State of Washington
DEPARTMENT OF FISH AND WILDLIFE

May 23, 2017

RE: WDFW comments on PD-16-00001 and LP-17-00004 MDJ Rezone and Long Plat near Currier Creek

SHEET NUMBER
 A1.0

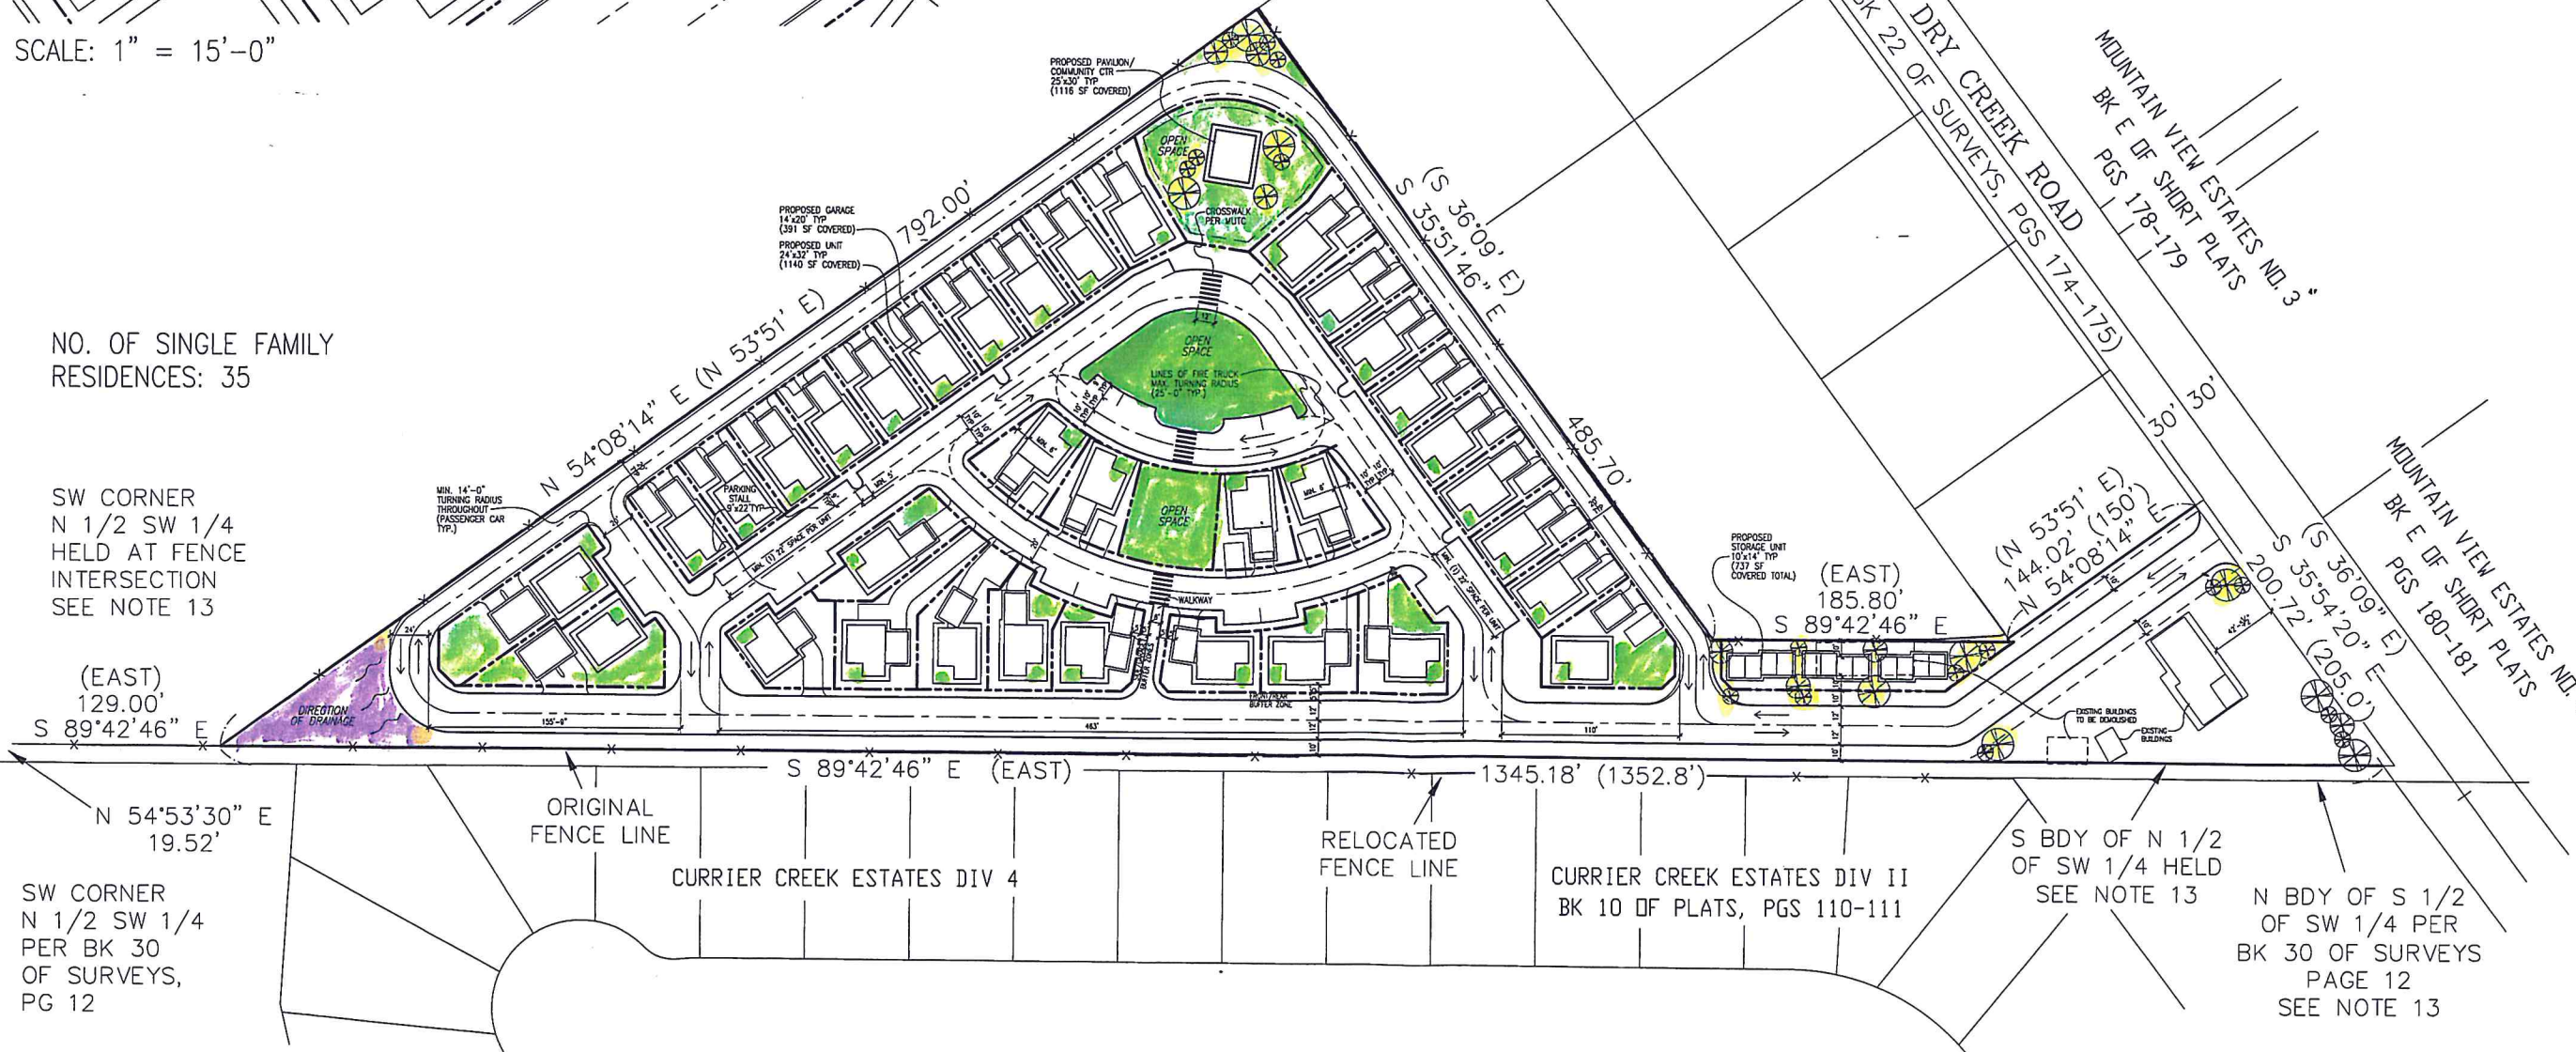
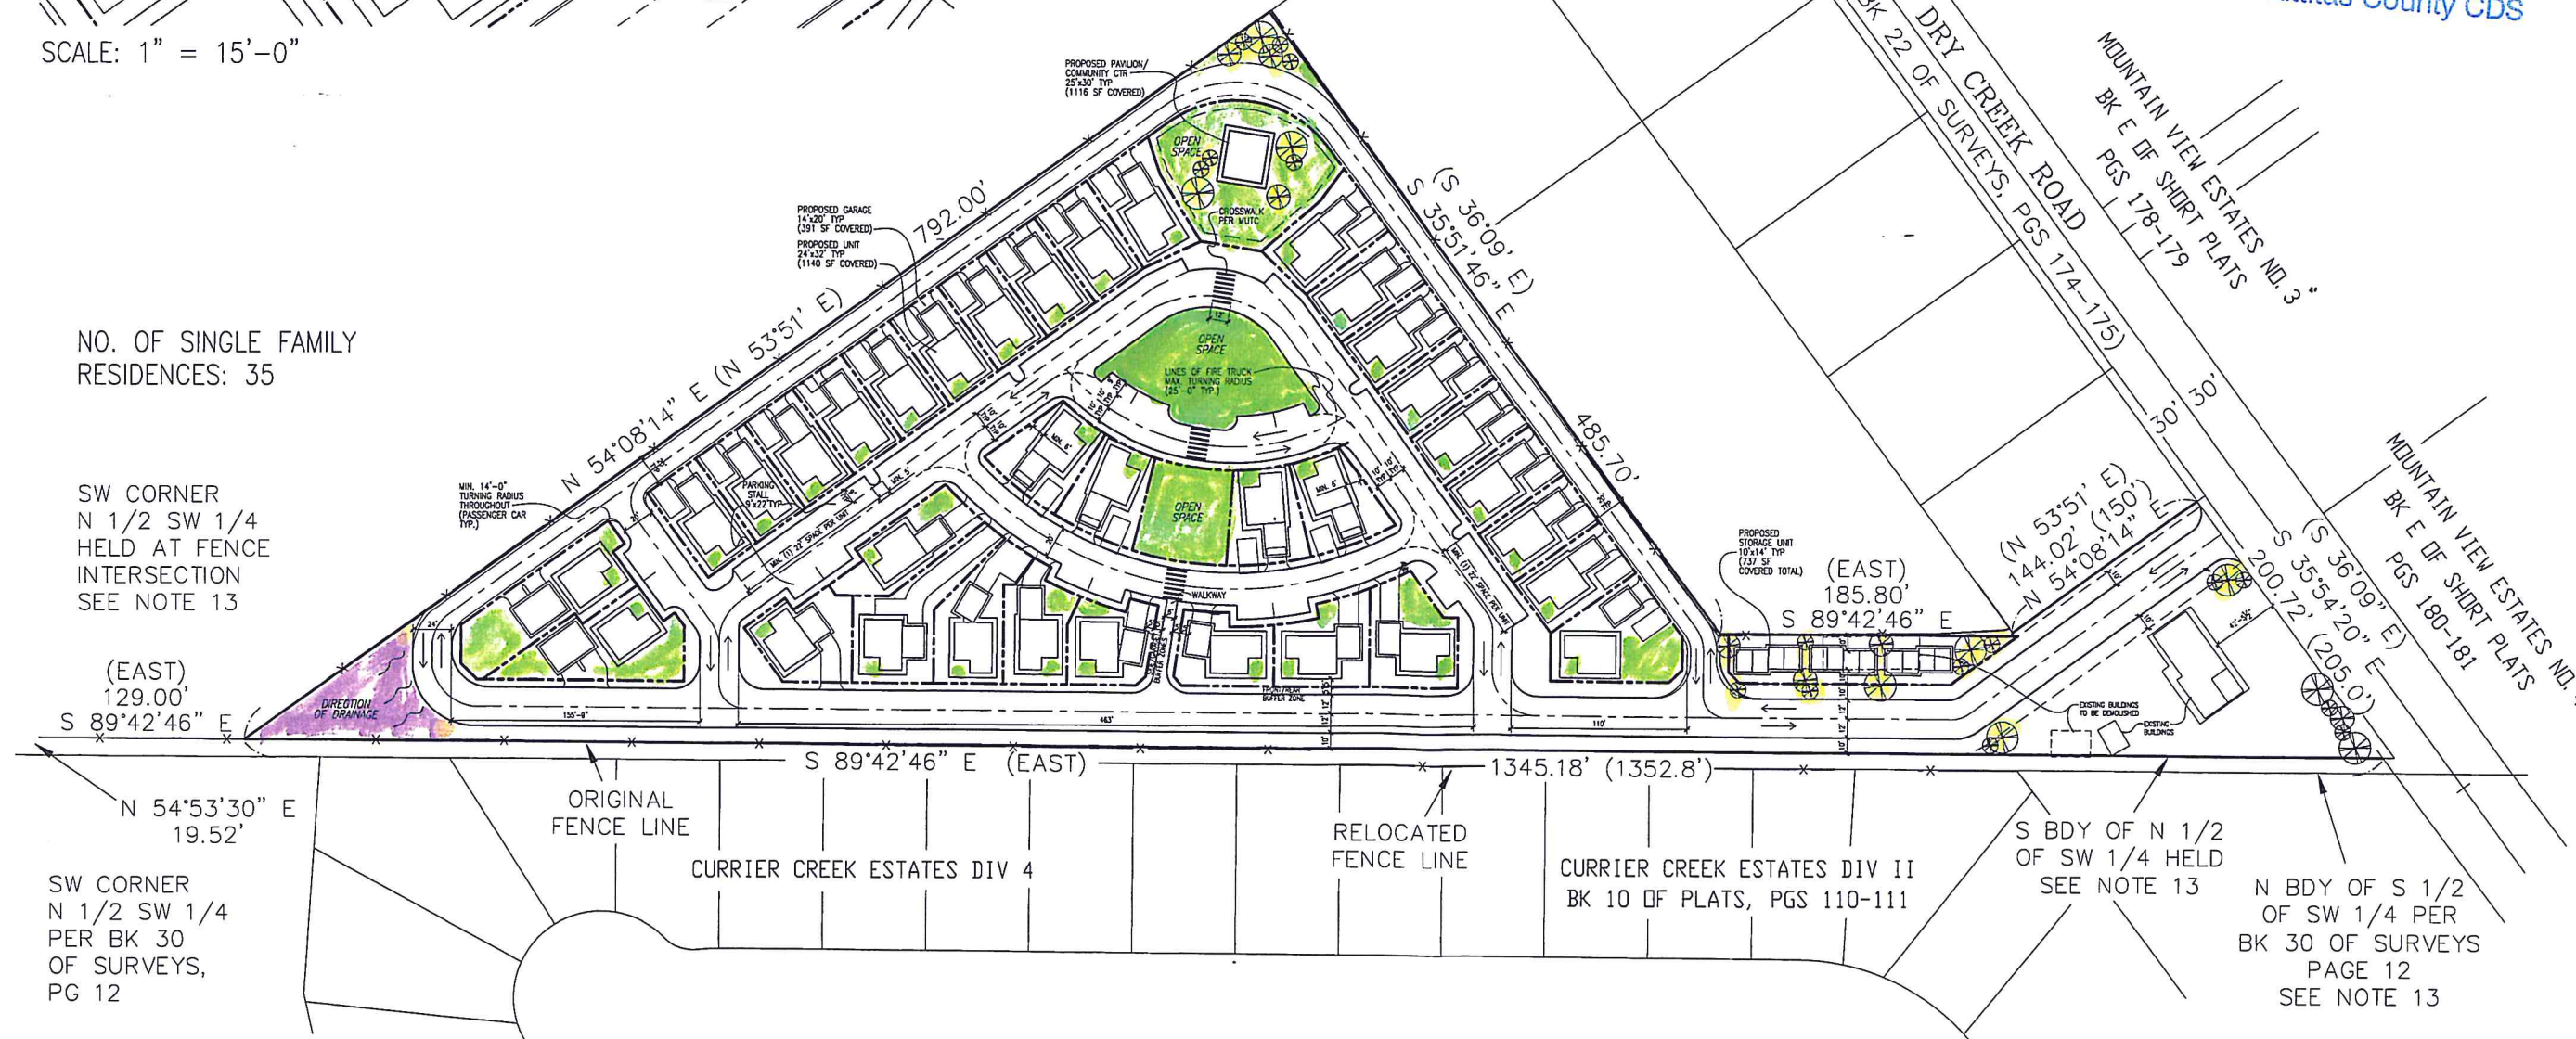
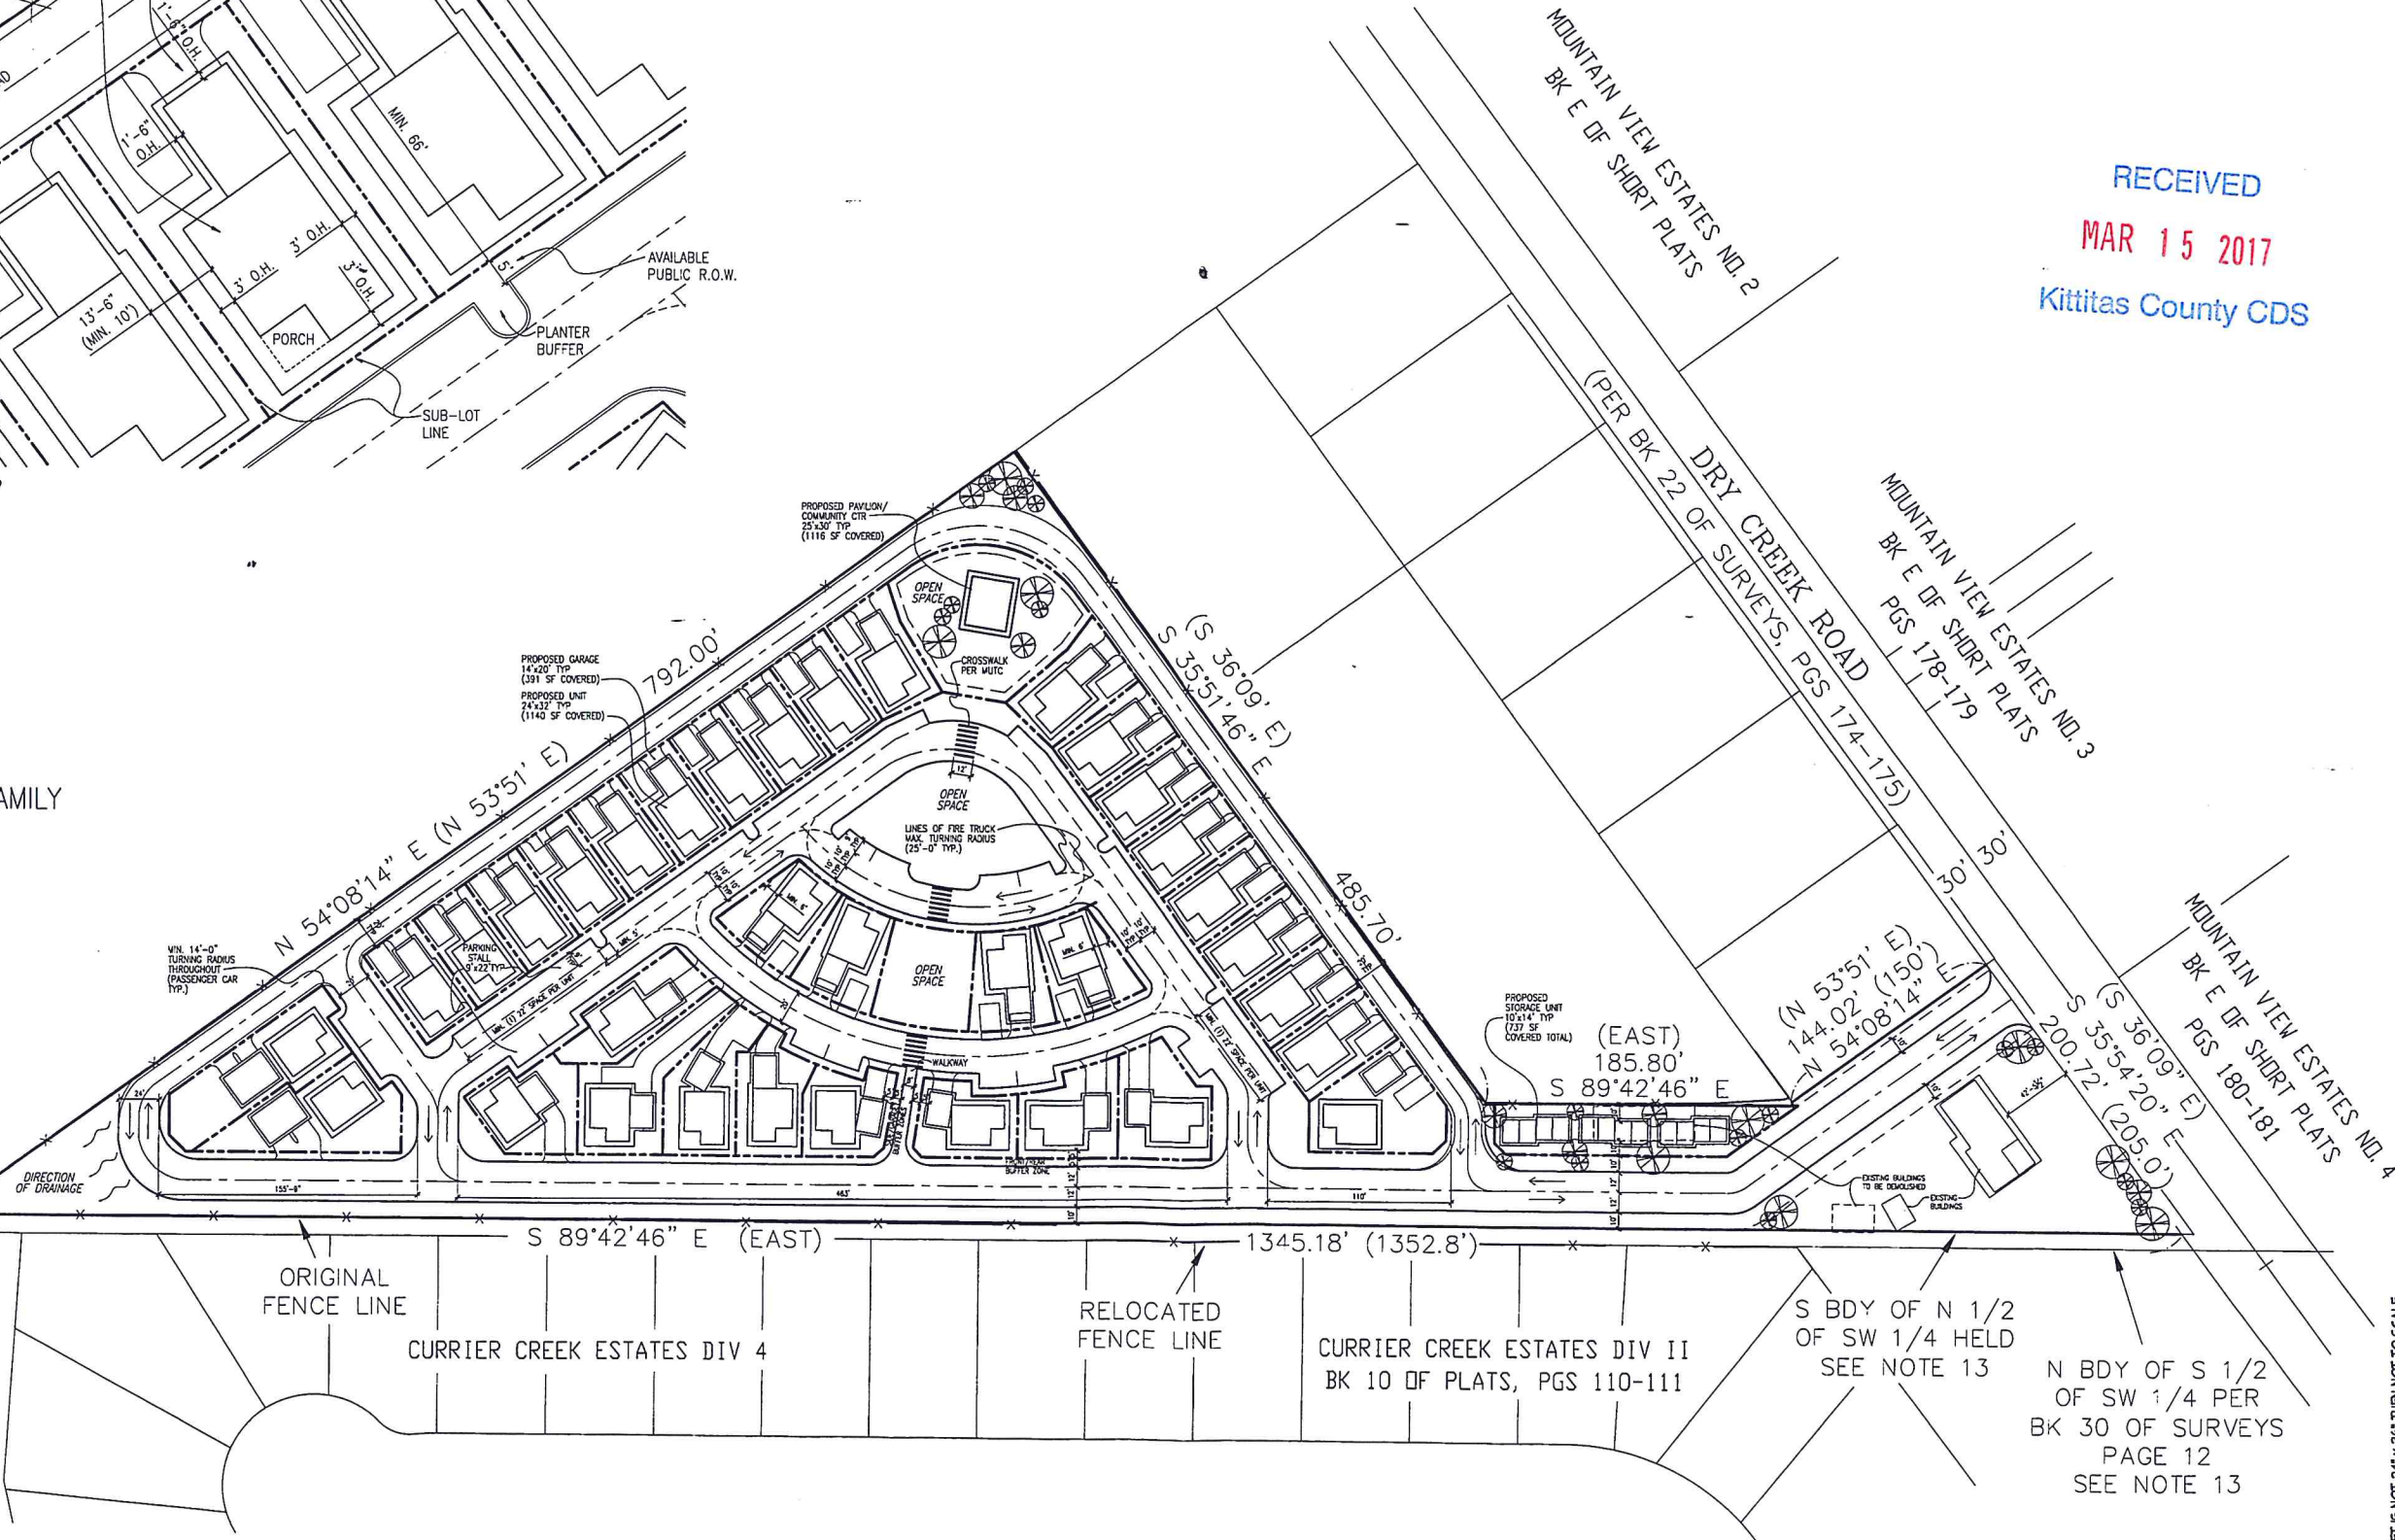
With the information provided to us for review, WDFW believes the proposed development will likely result in the new homes being flooded and increased flood risks to surrounding properties due to reduced floodplain capacity and impacts to wetland habitat. In light of the presence of surface water and potential for floodplain

impacts, an EIS may be warranted. In the very least, WDFW recommends delaying approval both the rezone (PD-16-00001) and long plat (LP-17-00004) until the following reviews and studies have been completed:

- Provide the wetland report referenced in the SEPA documents for public review and comment.
- Require a detailed study to determine whether or not the proposed development will increase flood risks to surrounding property owners and if the proposed new structures will be flooded. This study should also detail how flows (quantities and velocities) may be altered as they relate to Currier Creek and the fish and wildlife habitat associated with it.
- Require a detailed study to determine if there is a loss of floodplain conveyance and storage. Provide appropriate mitigation if warranted.
- If warranted based upon information from the studies mentioned above, reduce the lot density to allow for more floodplain storage. This may include enhancing wetland habitat within the proposed open space areas.

This is the proposed
 rezone and long plat for
 MDJ-Cottage
 Grove/Currier Heights.
 Currier Creek Estates is
 located immediately
 south of this
 development and
 homes along Creeks
 Edge Way already
 experience flooding.
